Planning Application Comments

Planning Application Number: 22/03063/F

Site Name: Land East of Larsen Road, Heyford Park

Proposal supported subject to revisions to the proposed affordable housing mix

DRAWING NO: 0778-620 HOUSE TYPE REF: SF58/59 TENURE: AFFORDABLE

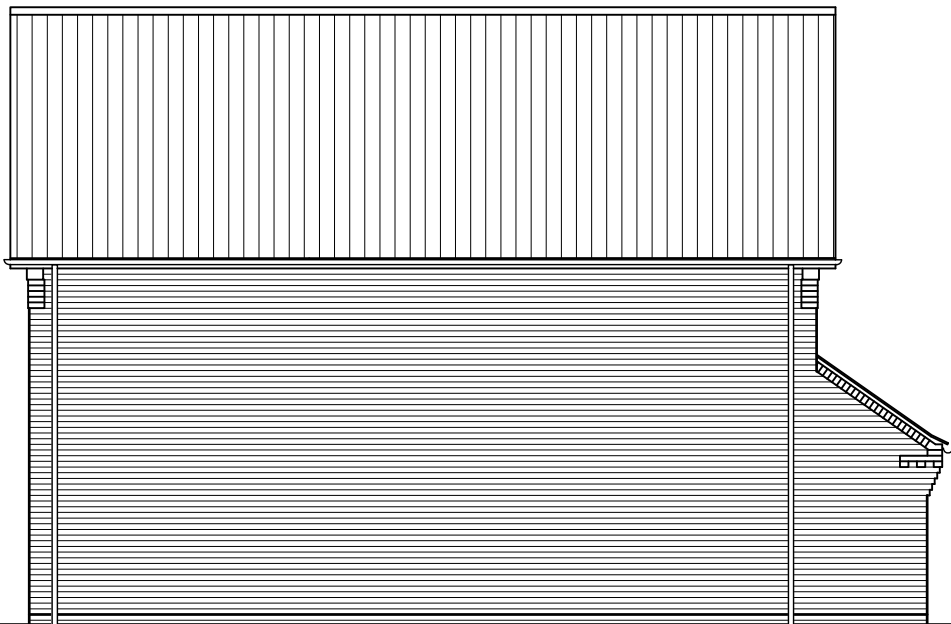
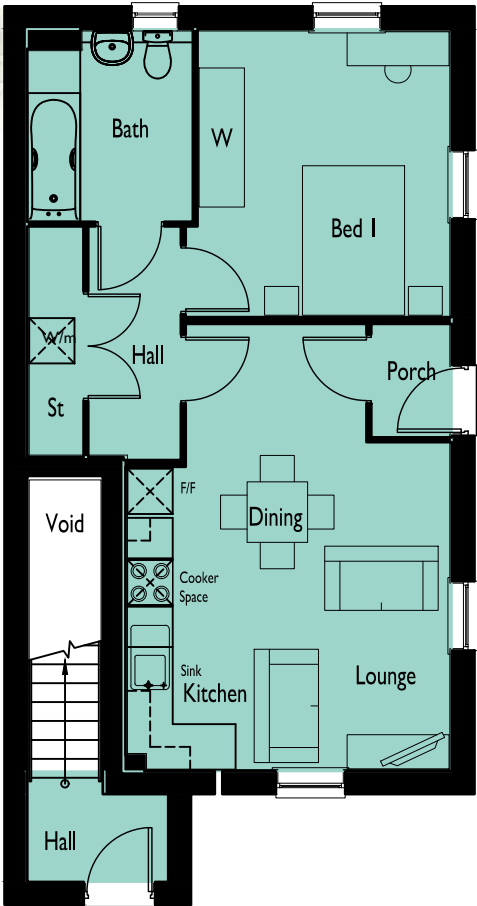
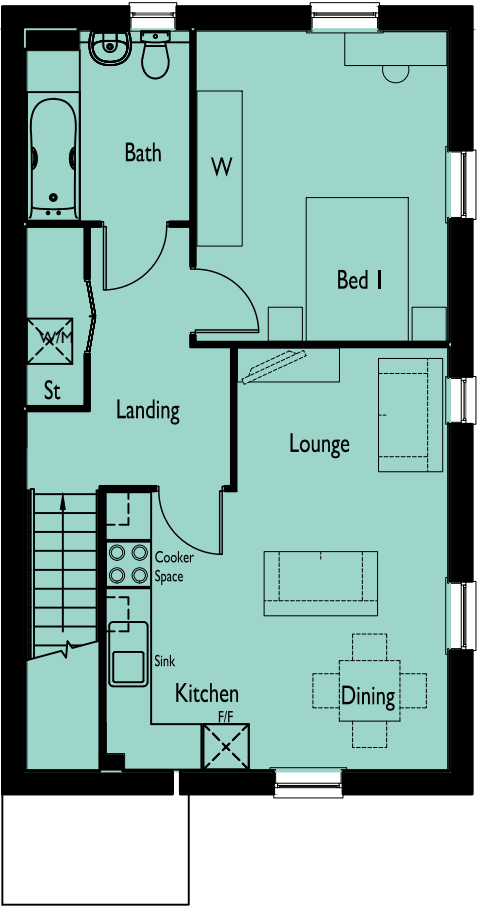
Waiting times are lower for 1-bed dwellings, however as a high proportion of the register is for 1-bed need, the Allocations team have advised that the affordable mix on new schemes needs to contain 35-40% 1-bed properties. The preferred property types for 1-beds are maisonettes, houses and/or bungalows.

We expect the rented dwellings to maximise person occupancy and to meet NDSS requirements for each size. So, as a minimum, 1-beds need to be 2-person, 2-beds need to be 4-person, 3-beds need to be 5-person and 4-beds need to be ideally 7 or 8-person and compliant with NDSS dimensions for these sizes.

- 12 x 1b2p maisonettes
- 1 x 4b house/bungalow M4 Category 3: Wheelchair user dwelling
- 5 x 2b4p houses
- 4 x 3b5p houses
- 3 x 4b7/8p houses

DRAWING NO: 0778-627 HOUSE TYPE REF: SH58 TENURE: AFFORDABLE

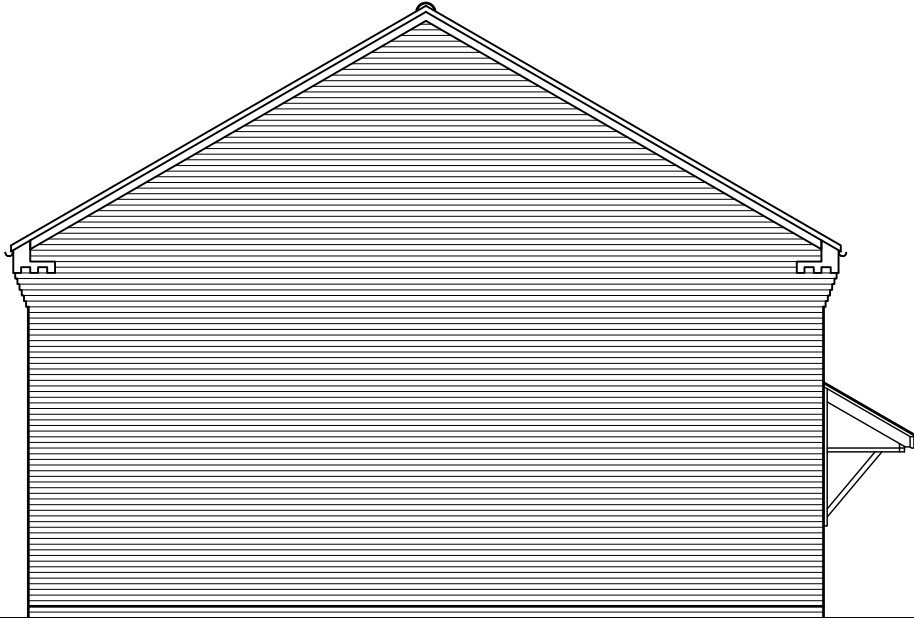
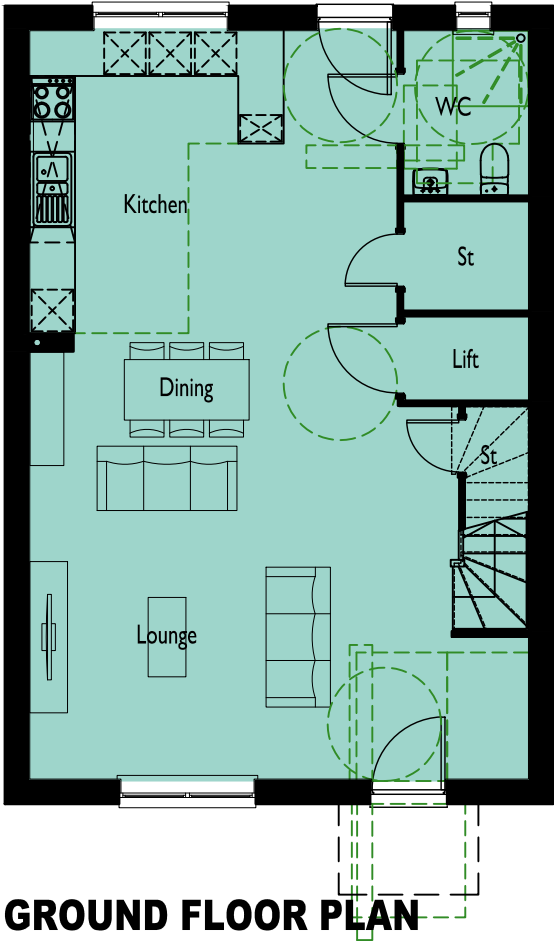
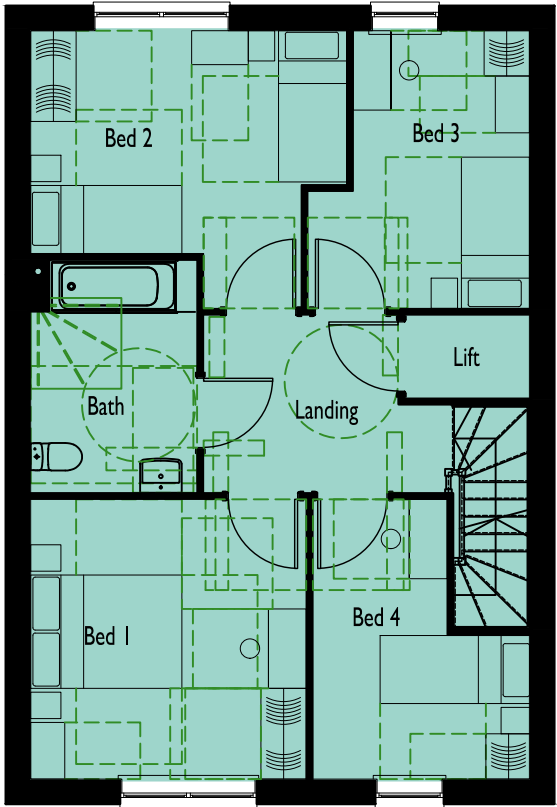
There is 1 household currently on CDC's housing register who specifically requires a 4-bed wheelchair adapted property in the Bicester area and they are having to wait indefinitely to be adequately housed due to the lack of supply. I have therefore included this in the suggested revised mix below and welcome discussions with the applicant regarding meeting this need. This would involve further discussions with the adaptations team to ensure that the requirements are up-to-date and also that the property is capable of being re-let in the future.
